DECISION DELEGATED TO DEVELOPMENT MANAGER

Application No: H09-0907-19 **Applicant:** Mr & Mrs J Henry

Proposal: Proposed single-storey extension to dwelling, construct front porch and alterations to rear porch

Location: Lark Rise Marsh Road Holbeach

No	Date	Revision
Issue:	For Planning Approval	
Site:	Lark Rise, Marsh Road, Holbeach, Lincolnshire, PE12 8JT	
Project:	Extension and Alterations	
Drawing Title:	Proposed Ground Floor Plans	
Client:	Mr and Mrs Henry	
Date:	September 2019	
Scale:	1:50	At: A1
Drawing Number:	16-1566-3

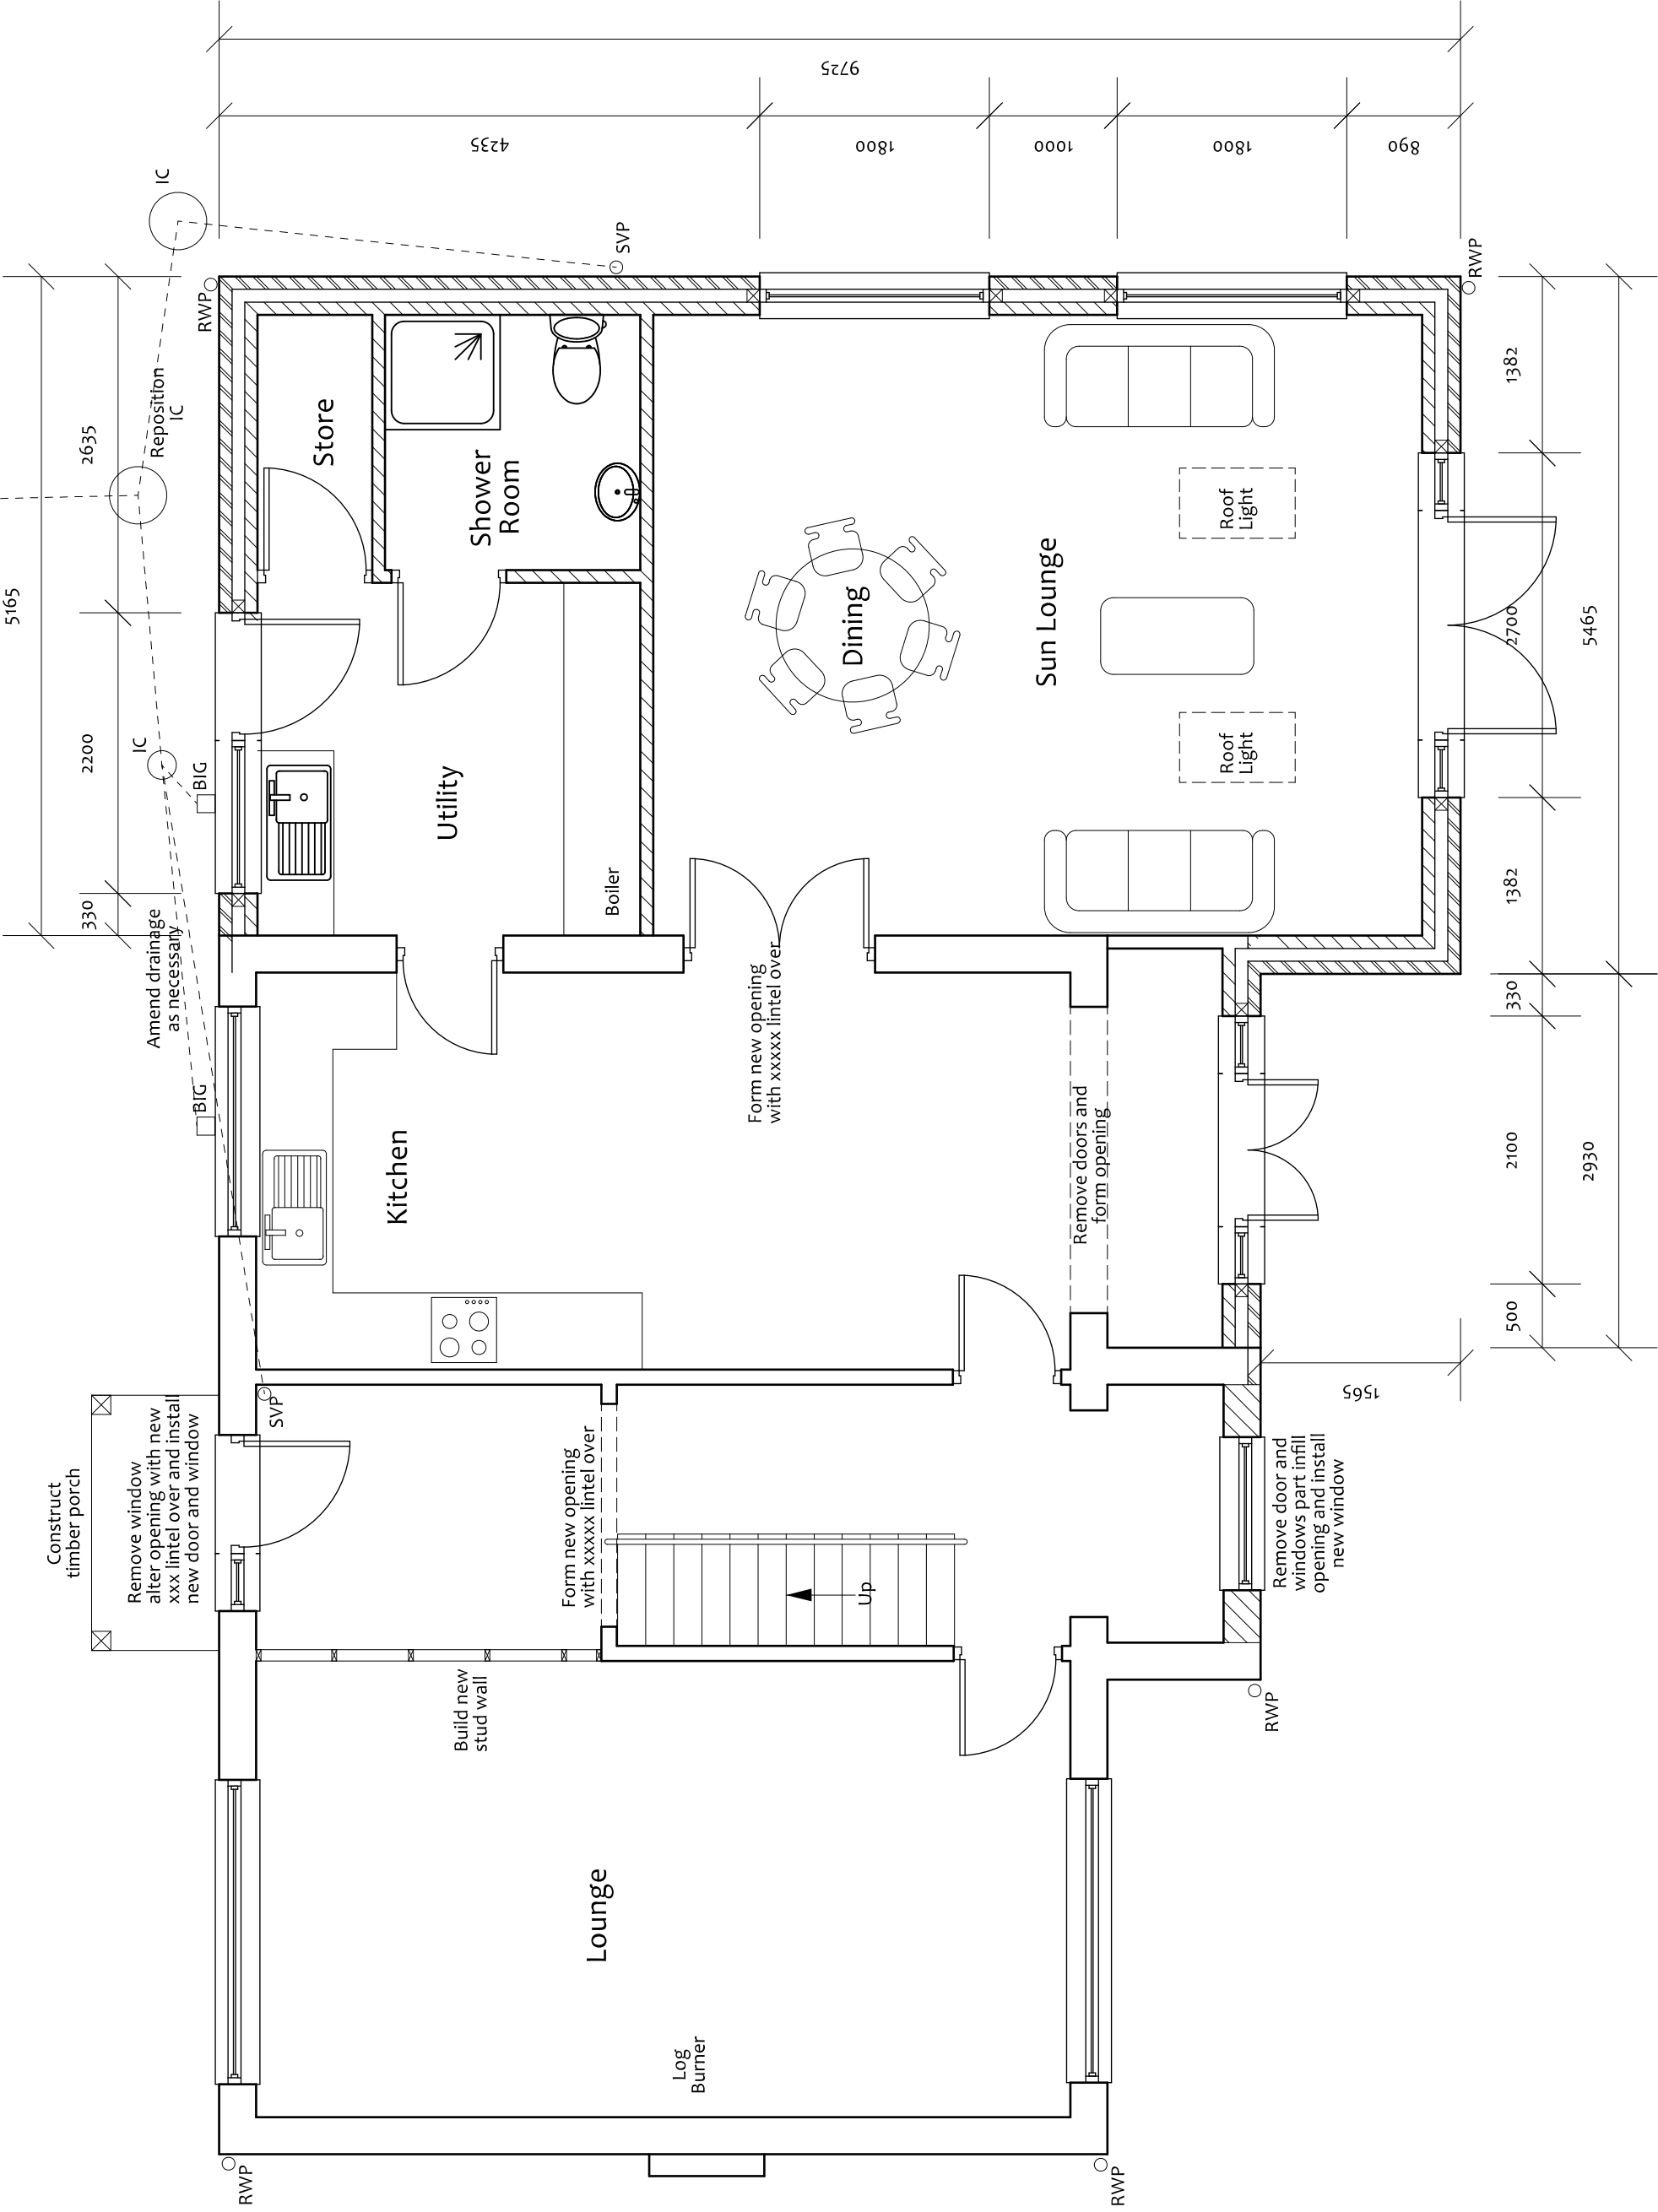
This proposed extension will replace an existing single-storey element to the west of the existing property and will be replacing the flat roof structure which is there currently.

The proposed design will create a hip roof, similar to the host property, which will better reflect the character of the existing dwelling and will appear better in visual terms from the front compared to what is there now.

As well as this, the plans show the construction of a new front door and porch, central to the original property. This adds visual interest to the front elevation.

The extension will be flush with the original property at the front of the dwelling. The rear part of the extension will be going further out in length to the rear of the property to create a slight L shape. This is acceptable given the size of the plot.

The proposed plans will create roof lights to the rear of the extension, with two patio doors with sidelights on the rear elevation. This will create more light into this part of the dwelling. The new windows and doors will not have an overlooking impact on neighbours due to most of the windows being north facing and no dwellings being located in this direction, as well as not overshadowing private areas of neighbouring houses and their gardens due to the single storey nature of the proposal.

There will be an addition of small windows to the side of the extension, which is on the west side, closest to the property on the west. However this will not have an adverse impact in terms of overlooking of that property due to the approx. 1.8m high conifer hedge which is situated between properties.
